Ms Poonam Chauhan
Development Manager
UNIT 4 161
REDFERN STREET
REDFERN NSW 2016

**Doran Drive Plaza Precinct (SSD-15882721)
Response to Submissions Report**

Attachment A

Scale	Project No.	Drawn by	North
1:650 @A1, 50% @A3	19068		
Status	Dwg No.	Rev	
DA Submission	DA-720-301	02

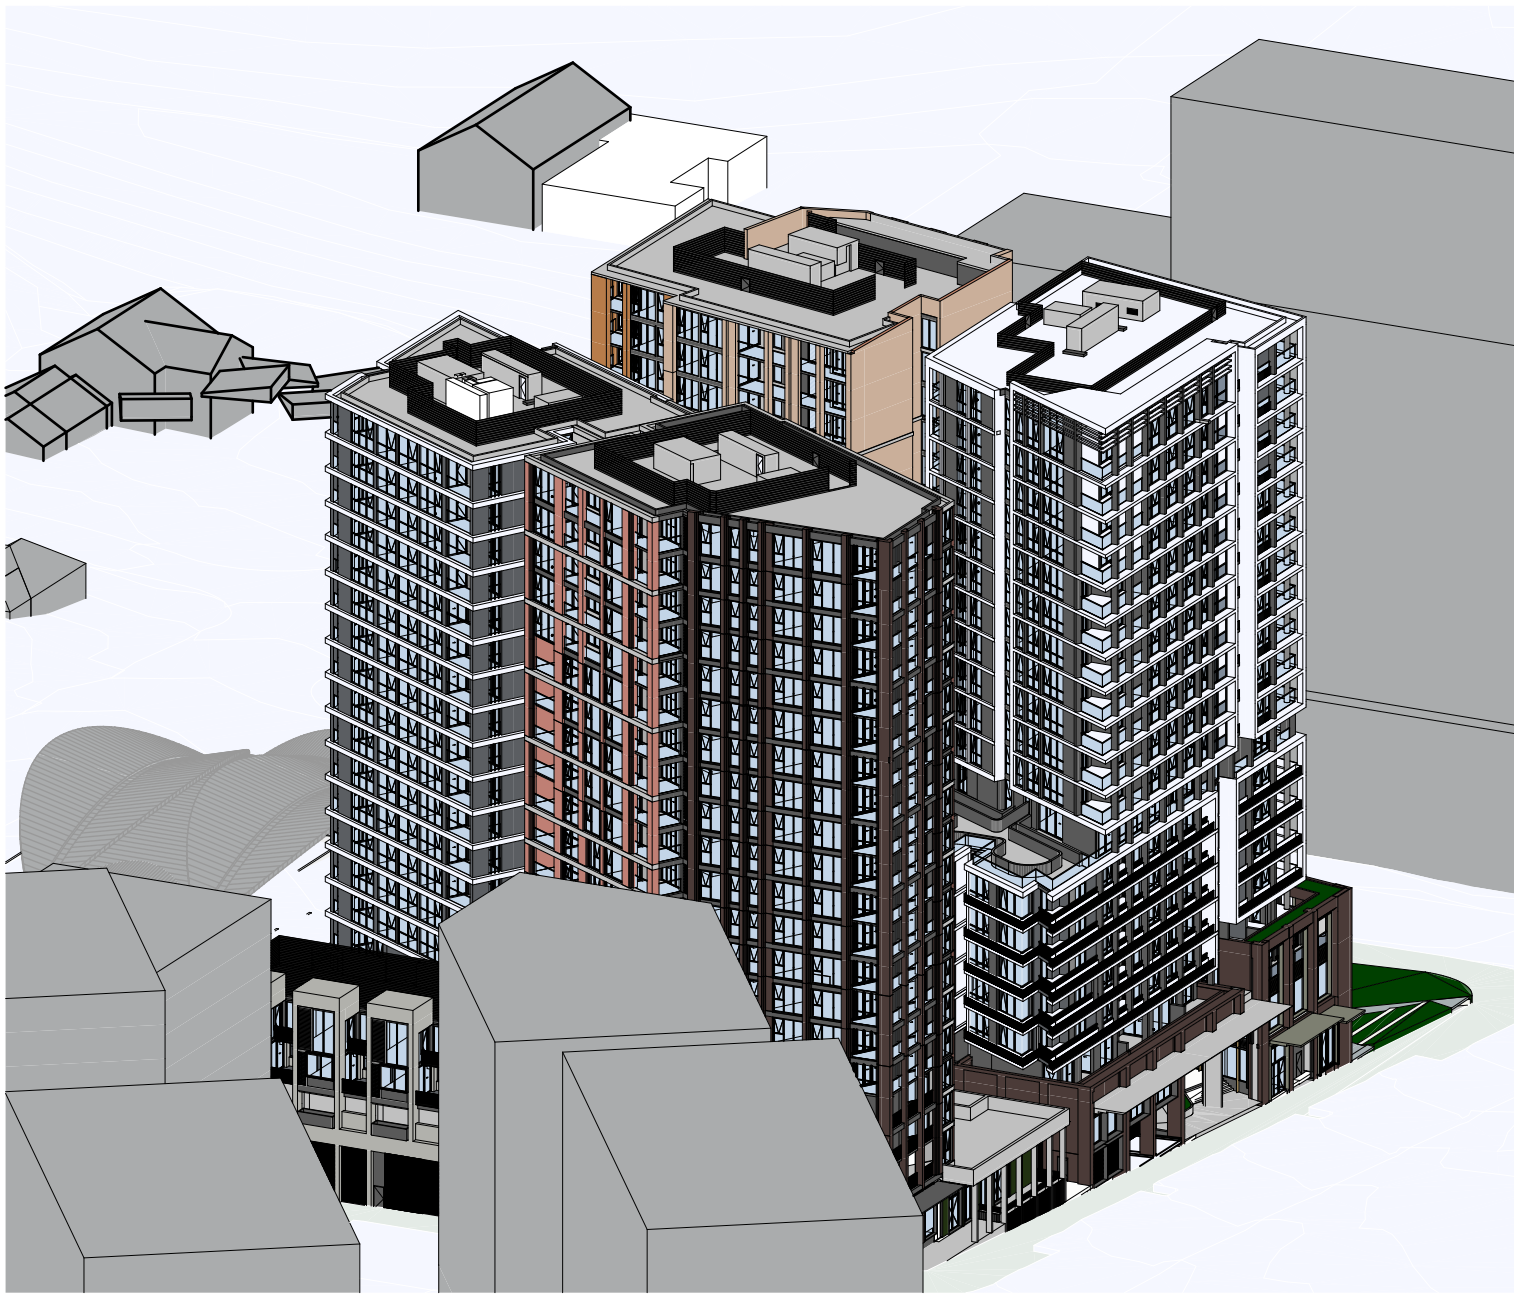
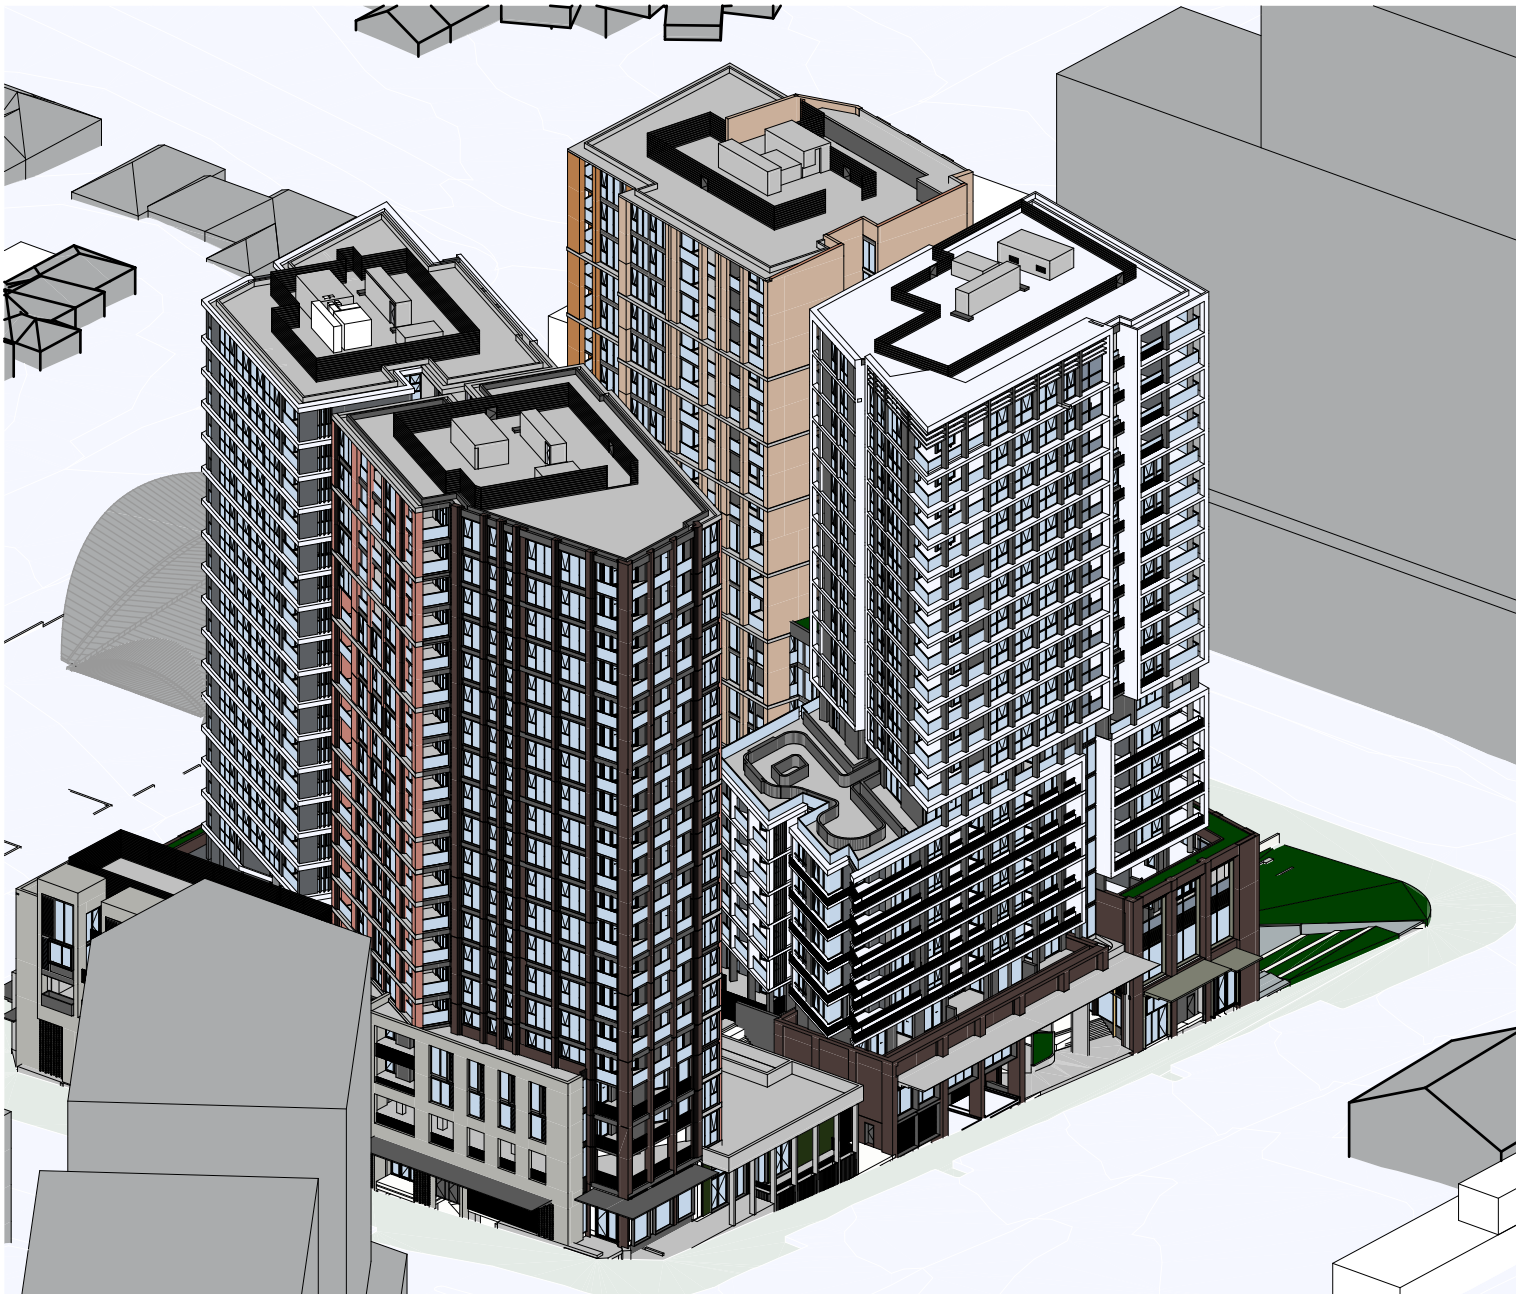
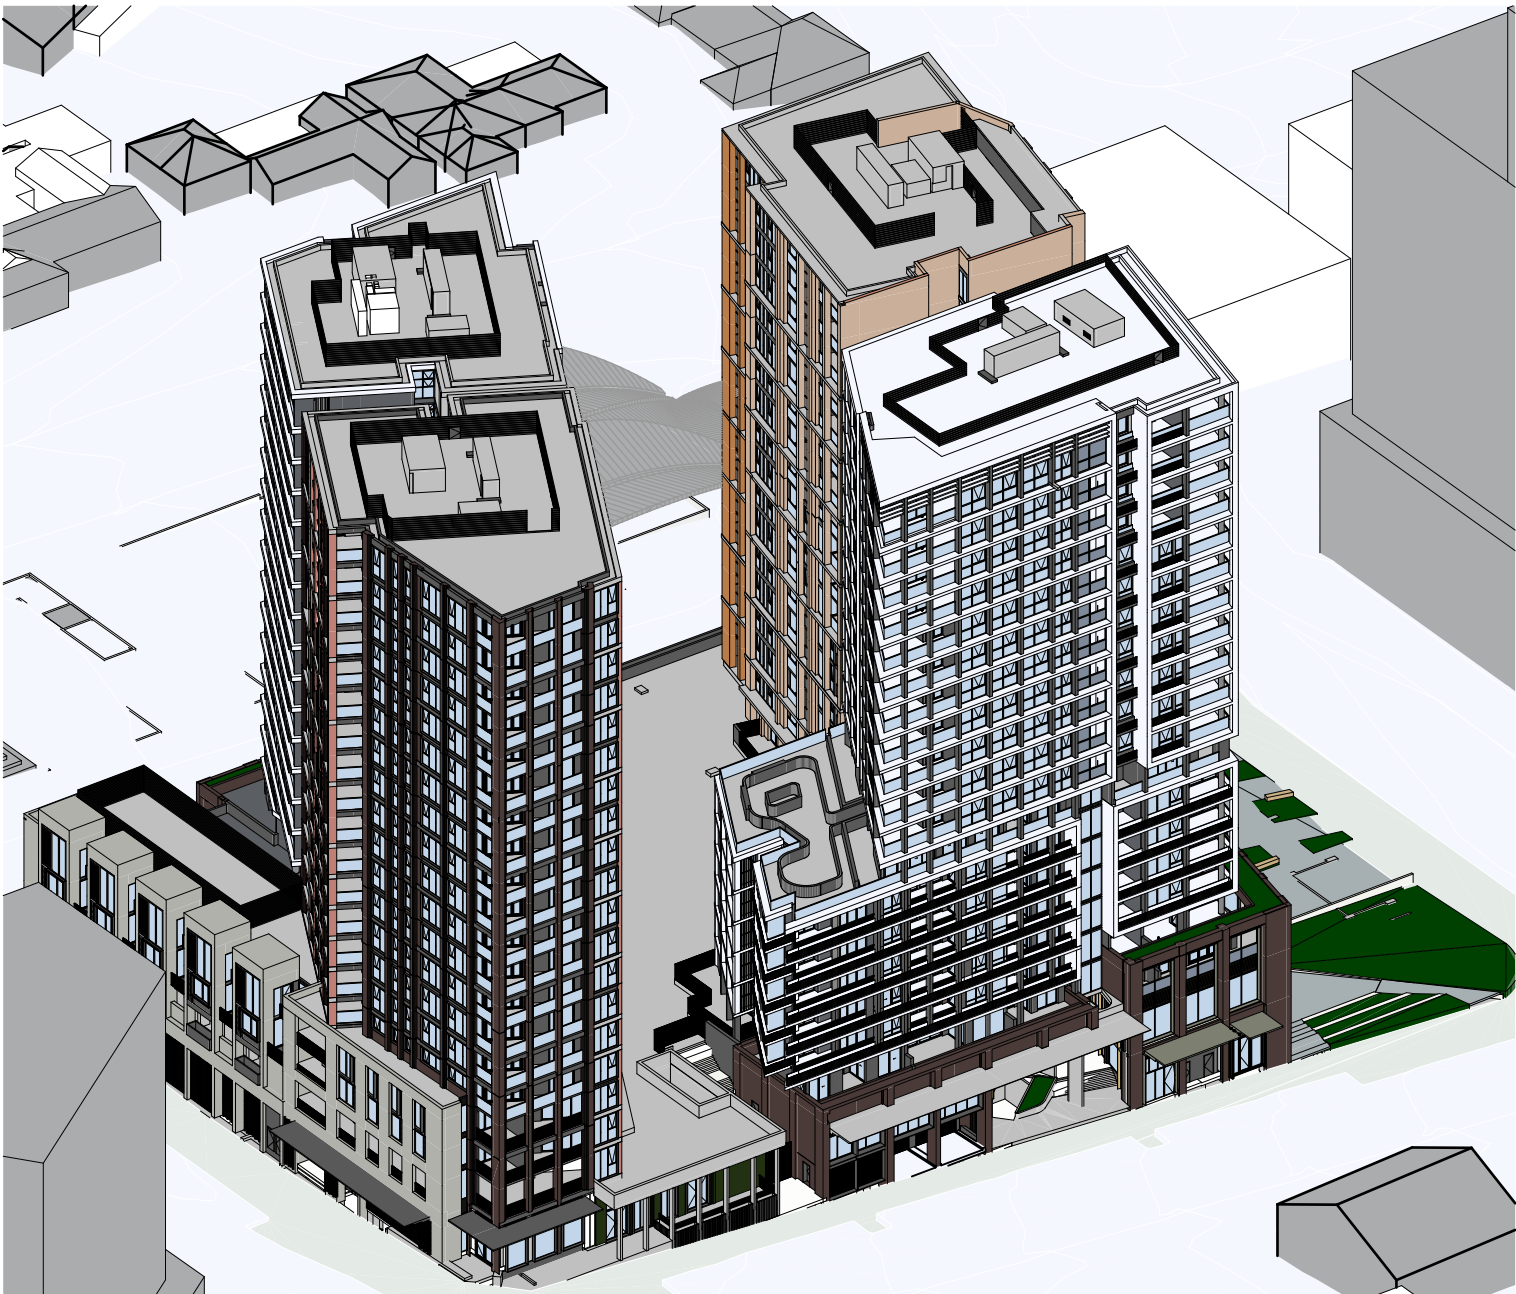
- solar eye diagrams at 15 minutes intervals for the proposed buildings, communal open spaces and adjoining public open spaces
 - detailed illustration of the extent of sunlight (area and duration) received at the living area and private open spaces, particularly for Typical Apartment 4 in Building D between levels 5 and 14, Typical Apartment 1 in Building D between Levels 5 and 19, and Typical Apartment 18 in Building B between Levels 2 and 18.
